Supporting Statement

Formation of a new 2 storey detached 2 bedroom (class C3) residential dwelling; including formation of waste storage; cycle store; parking and Amenity space for the existing and proposed dwellings

on :land at 1 Adelphi Crescent UB4 8LY

Issue – FDC/20/04/13
August /2020

PROPOSED FRONT ELEVATION

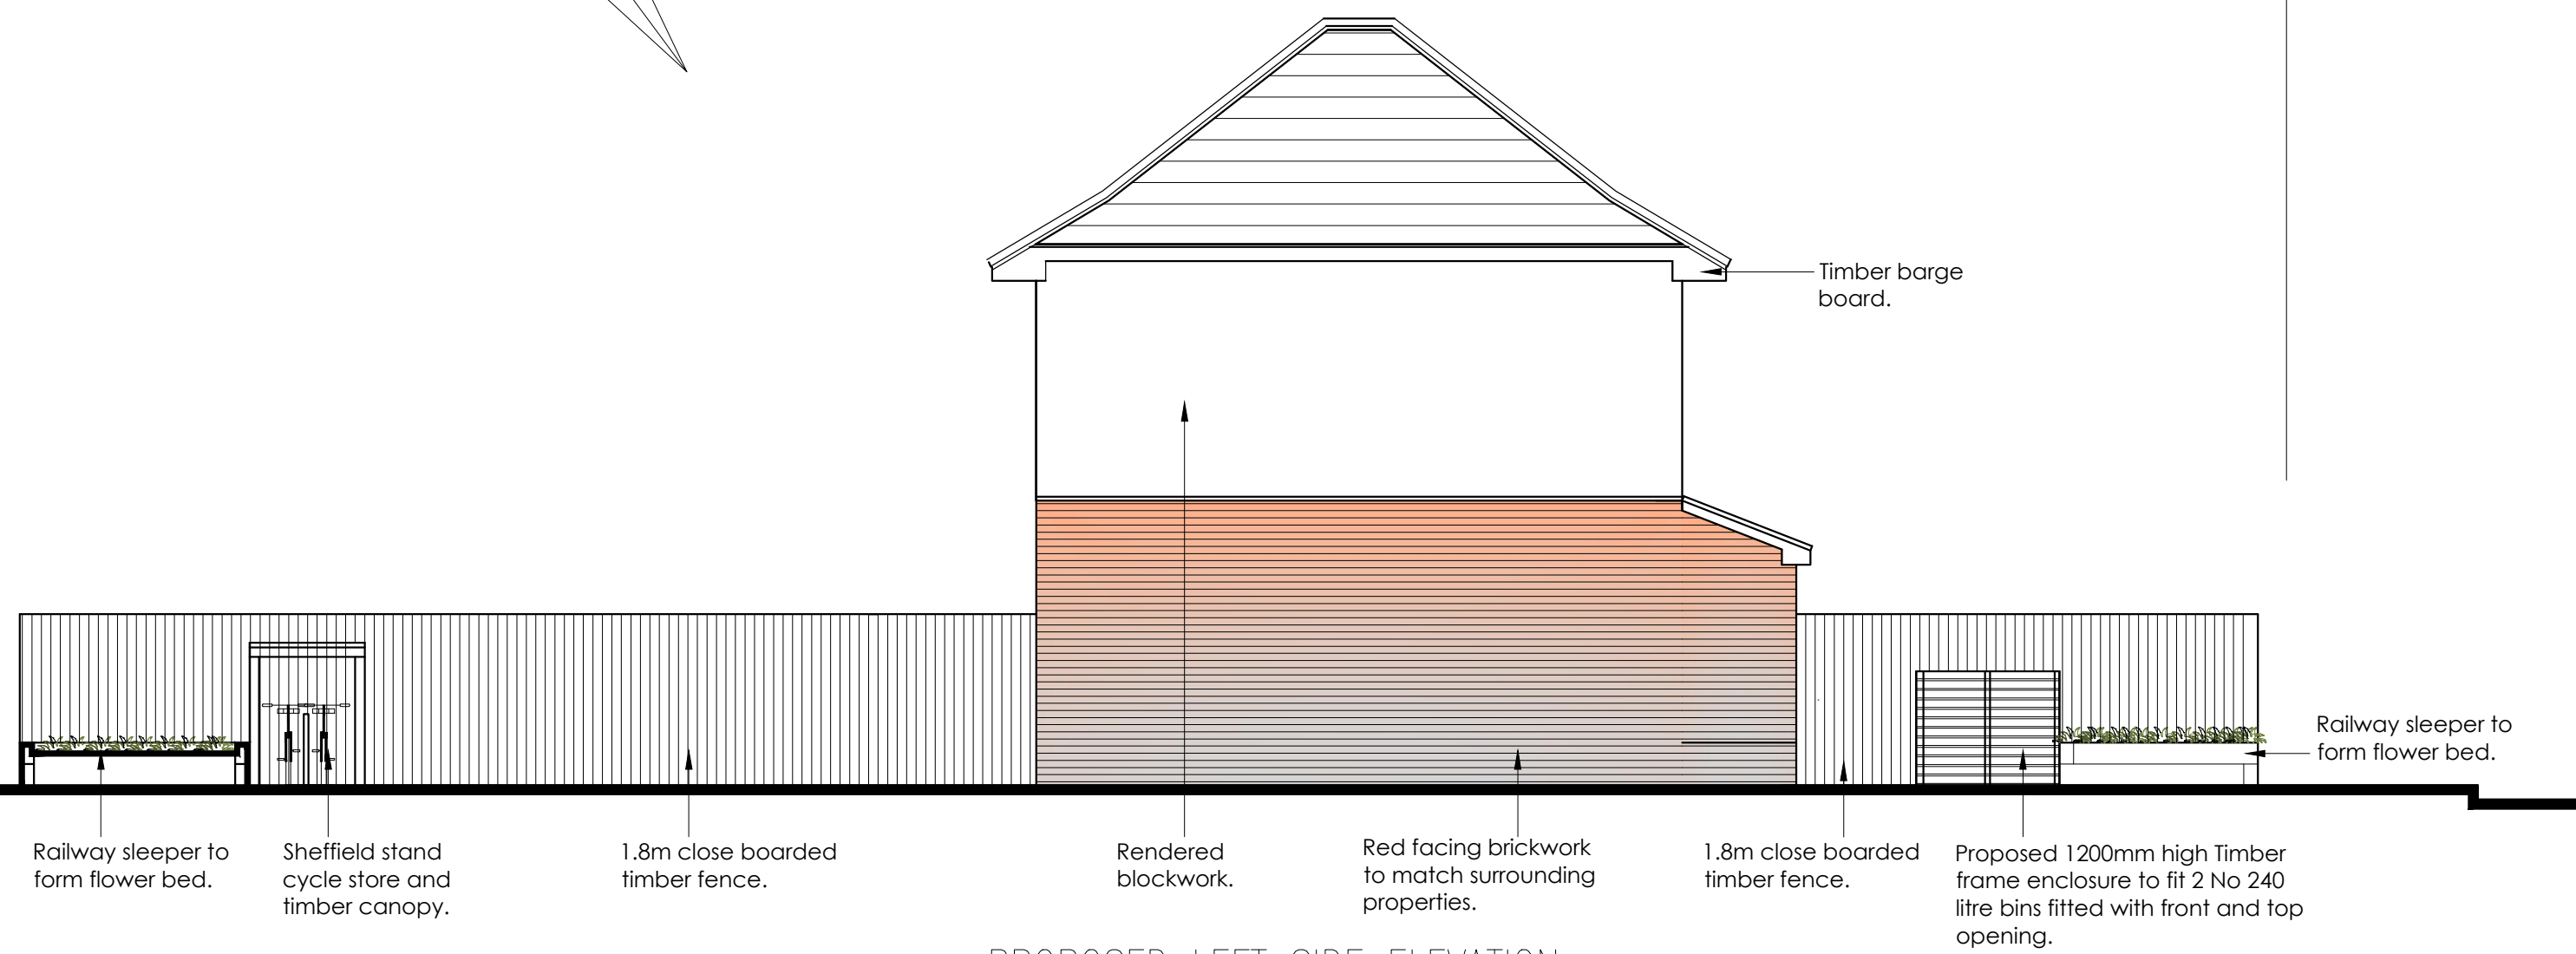
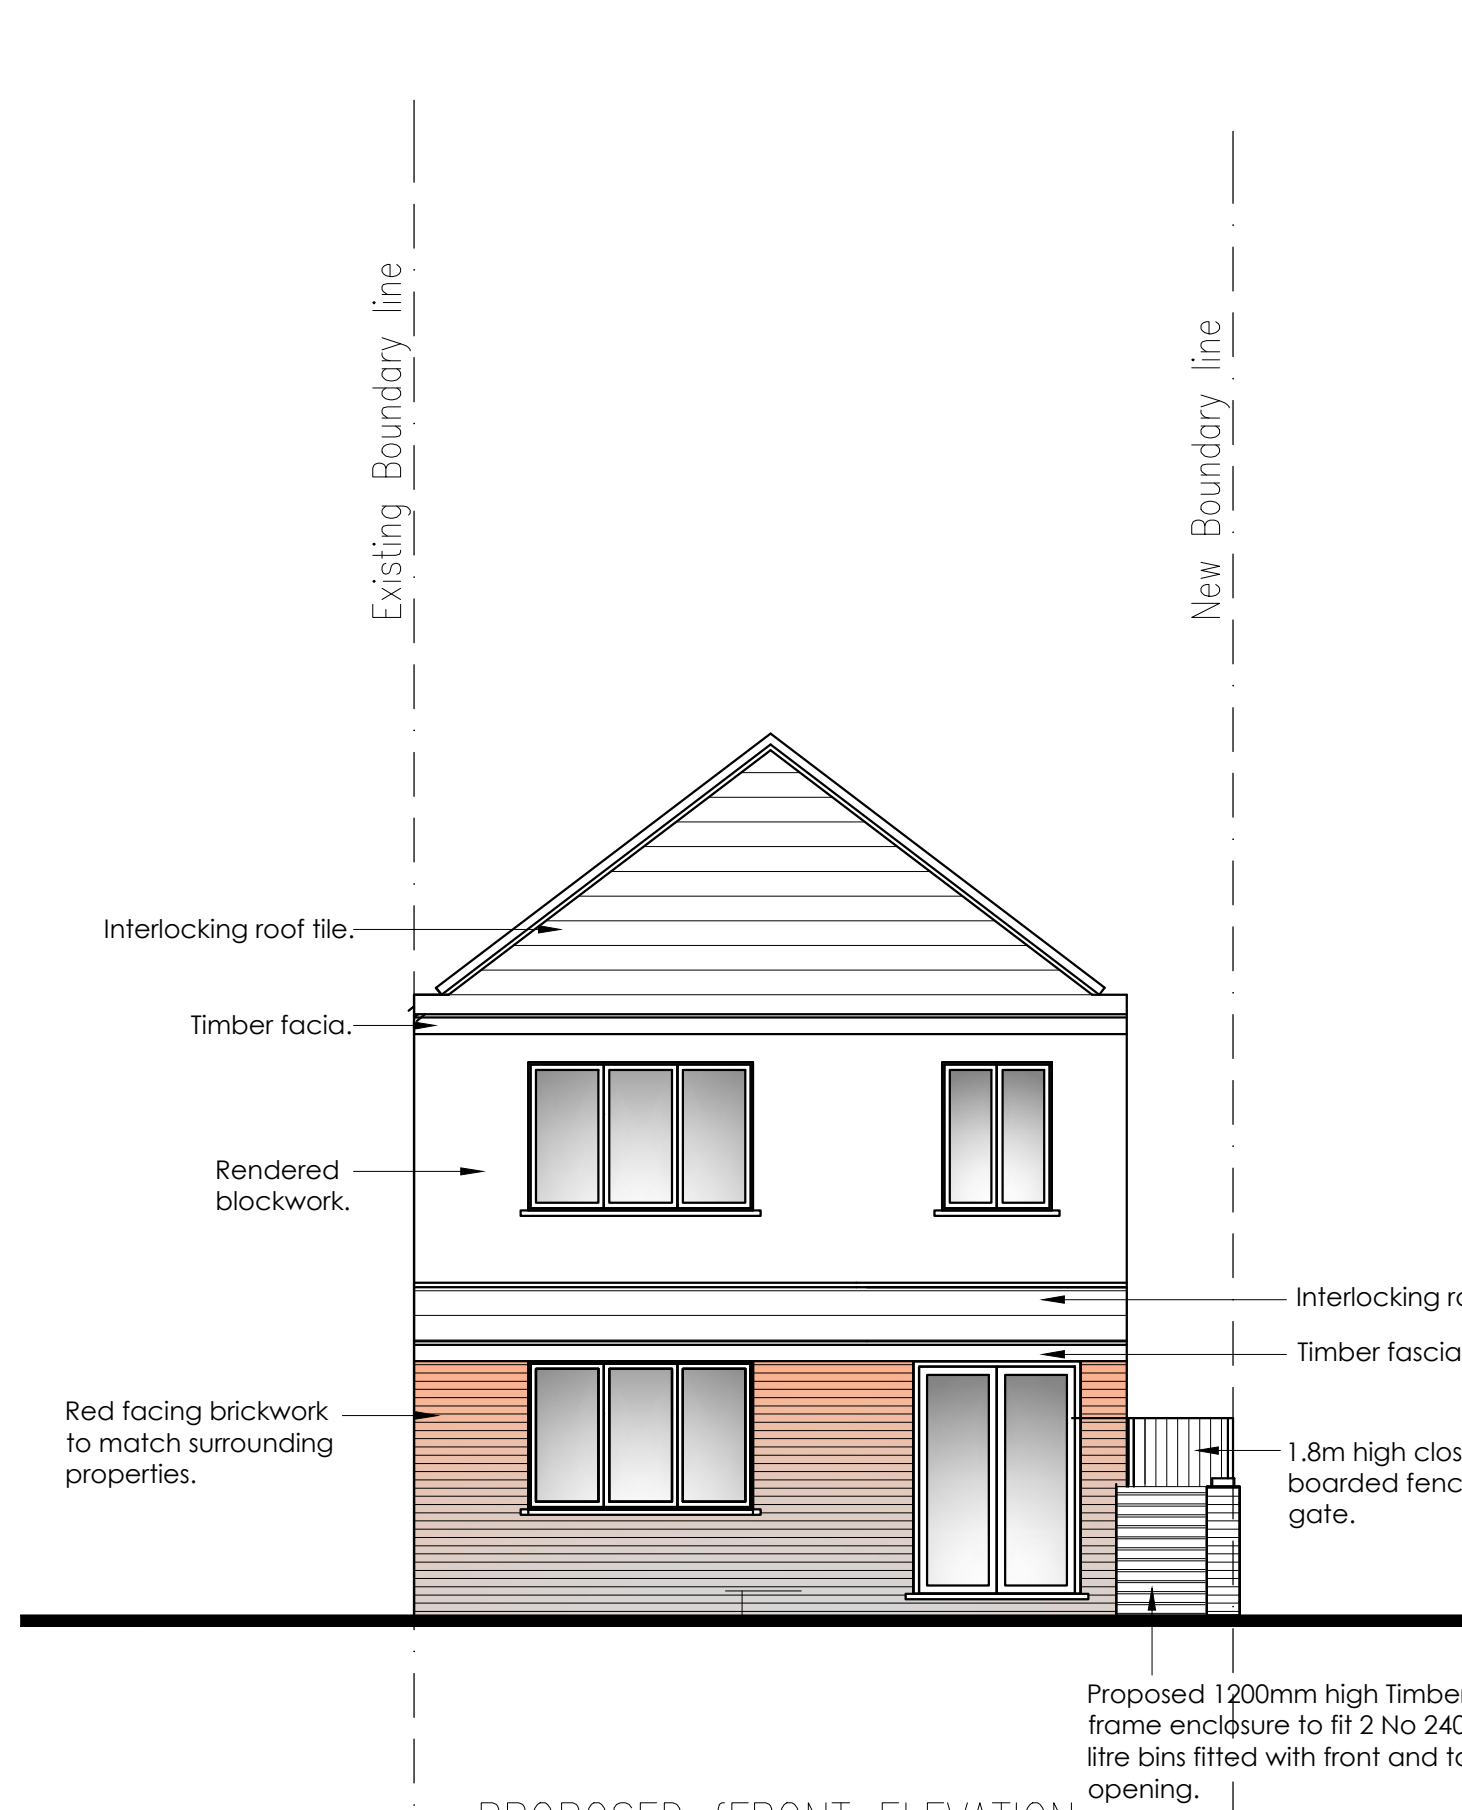
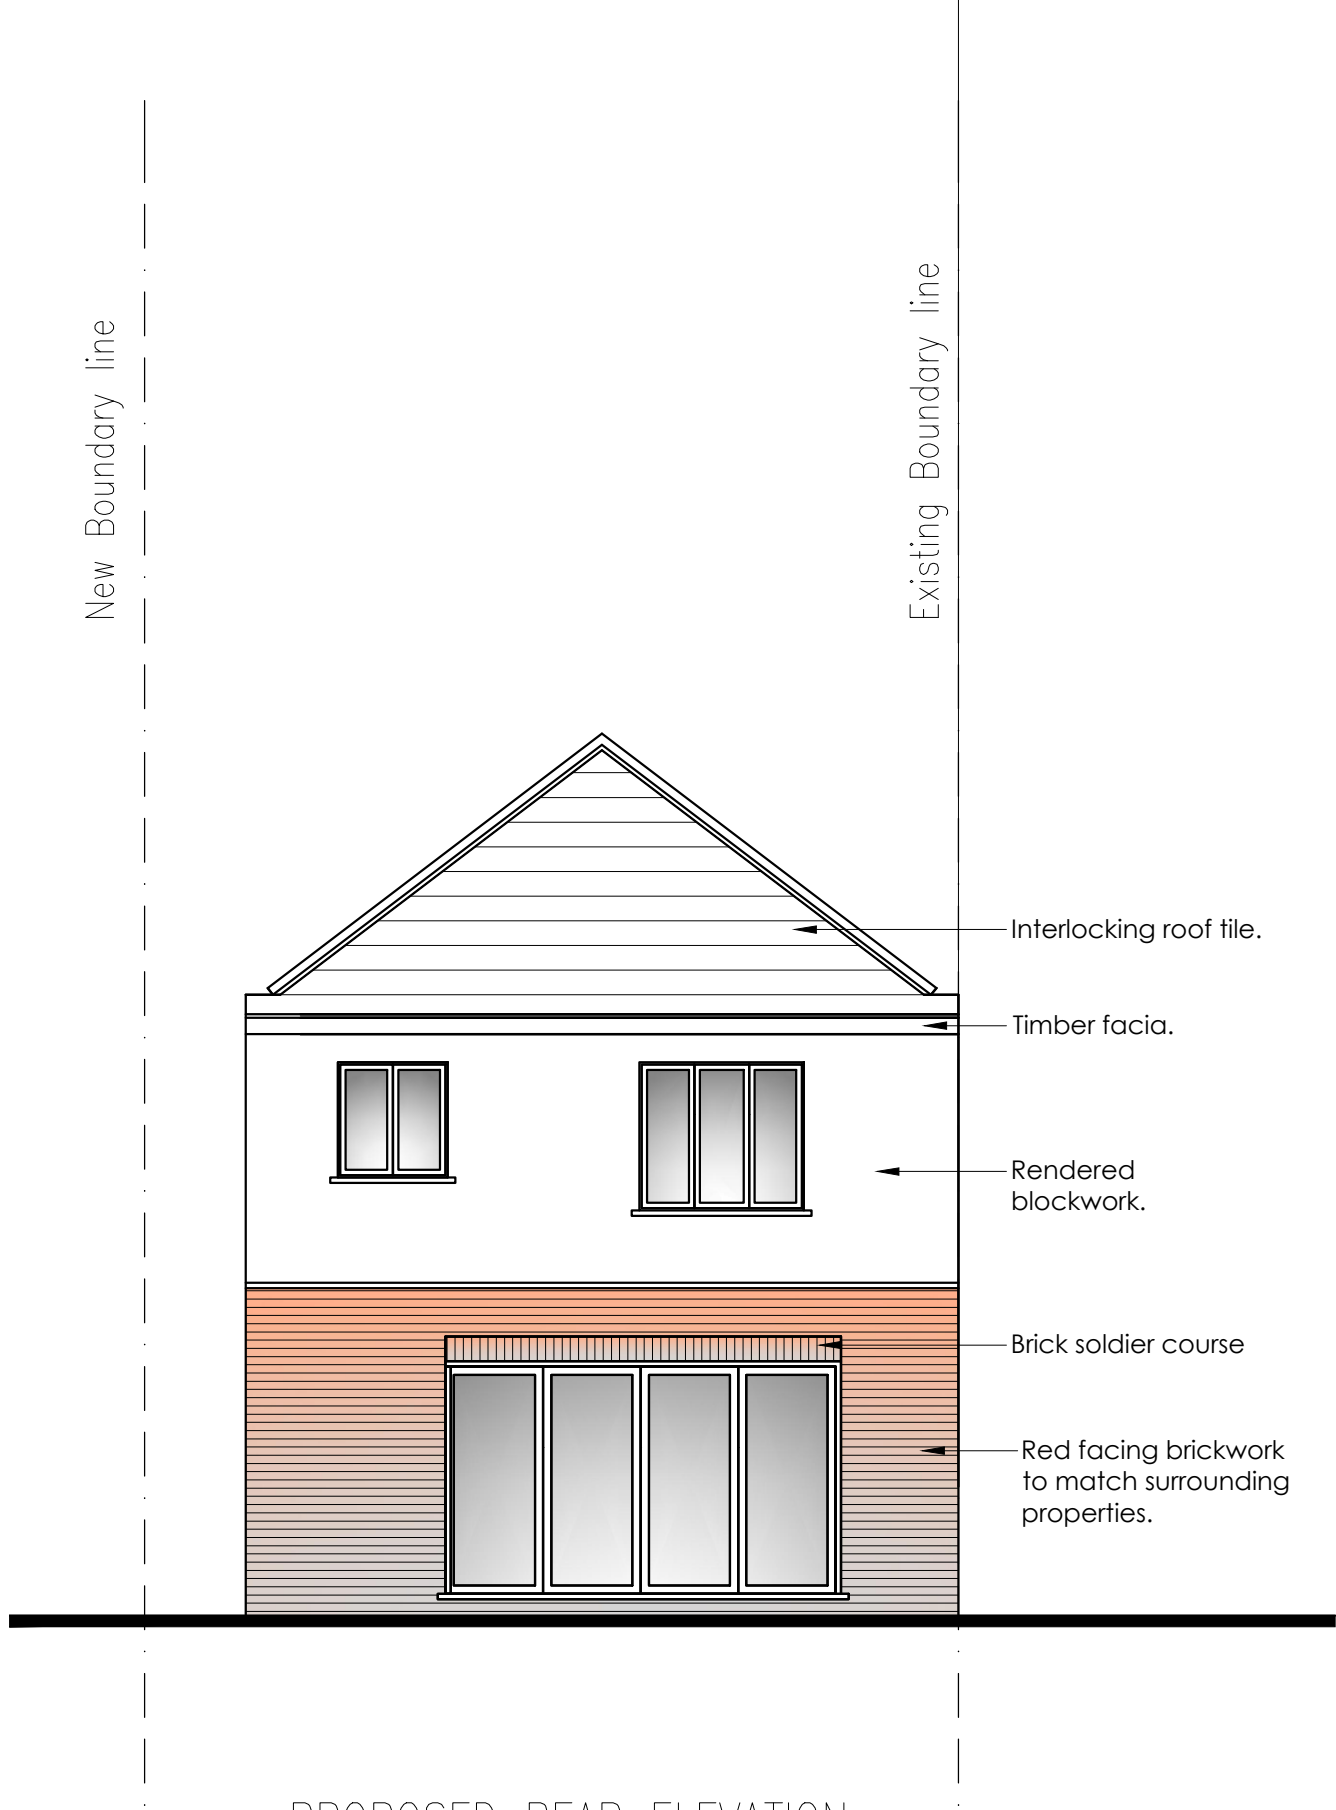
The appearance of the roof has been reduced and redesigned to be in keeping with the existing roofs. This also reduces the bulk of the building hence improving the character, appearance and visual amenities of the street scene and the wider area. See amended proposed plans and elevations.

2, The proposal by reason of its siting in this open prominent position, size, scale, bulk and gable roof design would be detrimental to the character, appearance and visual

We can change the roof design to a pitched roof to match other roofs.

PROPOSED NORTH EAST STREET VIEW (view from Adelphi Crescent).

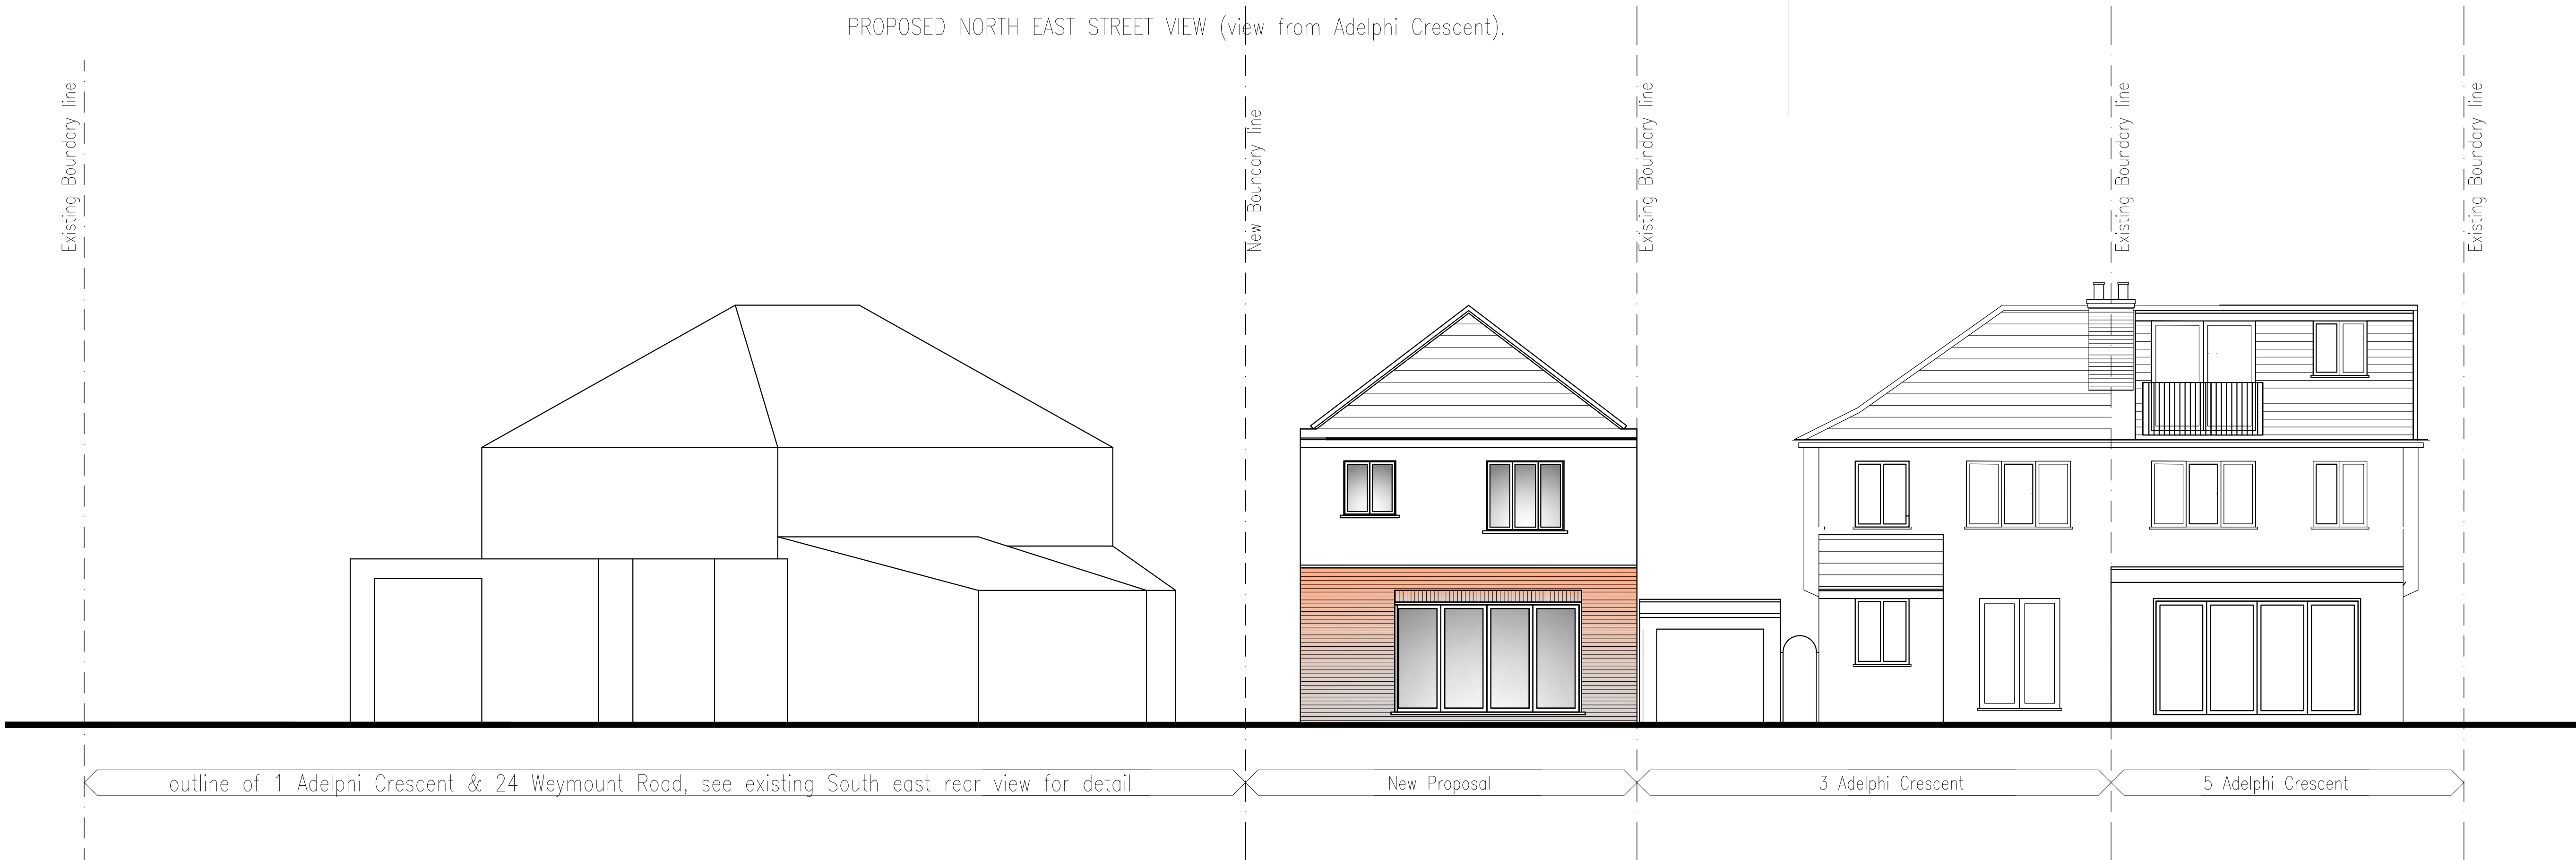
1, The proposal by reason of its siting in this open prominent position, size, scale, bulk and proximity to the side boundary would result in the loss of an important gap characteristic to the area, resulting in a cramped appearance. The proposal would therefore, represent an overdevelopment of the site to the detriment of the character, appearance and visual amenities of the area and to this existing open area of the street scene.

Table R2 and drawing No: FDC20/04/12 demonstrates that the gap between the proposal and the existing building on 1 Adelphi Crescent is the widest compared to existing similar scenario on neighboring buildings.
